STATE OF WASHINGTON  
DEPARTMENT OF ECOLOGY

October 27, 2015

Re: SP-15-00004

Thank you for the opportunity to comment on the short subdivision of 21.00 acres into 4 lots, proposed by Harlan Odegard. We have reviewed the application and have the following comments.

FILBERT ESTATES SHORT PLAT
 PREPARED FOR
 HARLAN ODEGARD
 A PORTION OF THE N 1/2 OF THE NW 1/2 OF SECTION 29,
 TOWNSHIP 20 N., RANGE 14 E., W.M.

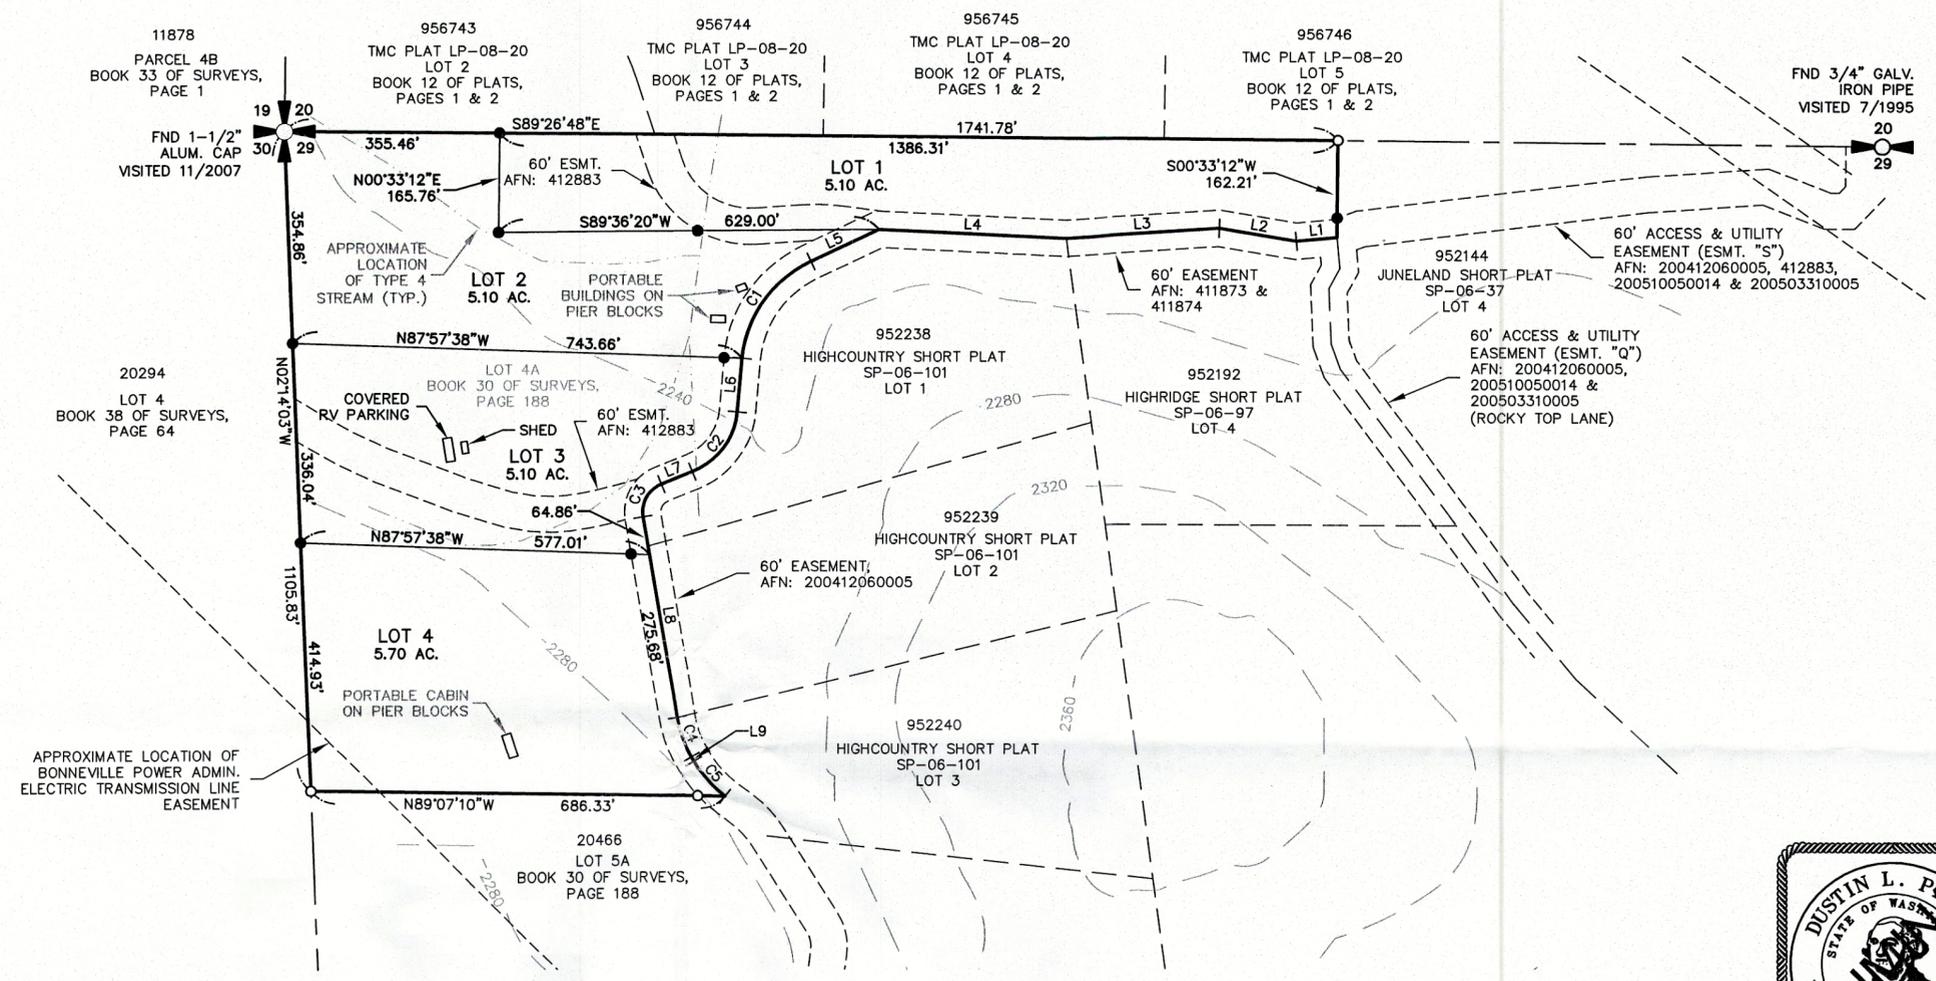
It appears from aerial photo observation and the fact that multiple streams meet on this relatively flat area that there are wetland areas on this parcel that have not been identified. Aerial photo review also show that residential development has already occurred on all the proposed lots except lot 1. A wetland report which includes a wetland delineation and a wetland rating should be prepared for the parcel to find out if existing development has intruded into wetlands or their required wetland buffers. If wetlands or their buffers have been impacted, a wetland mitigation plan should be submitted before additional development takes place. Ecology would be happy to assist the County with a site visit to verify the presence of wetlands.
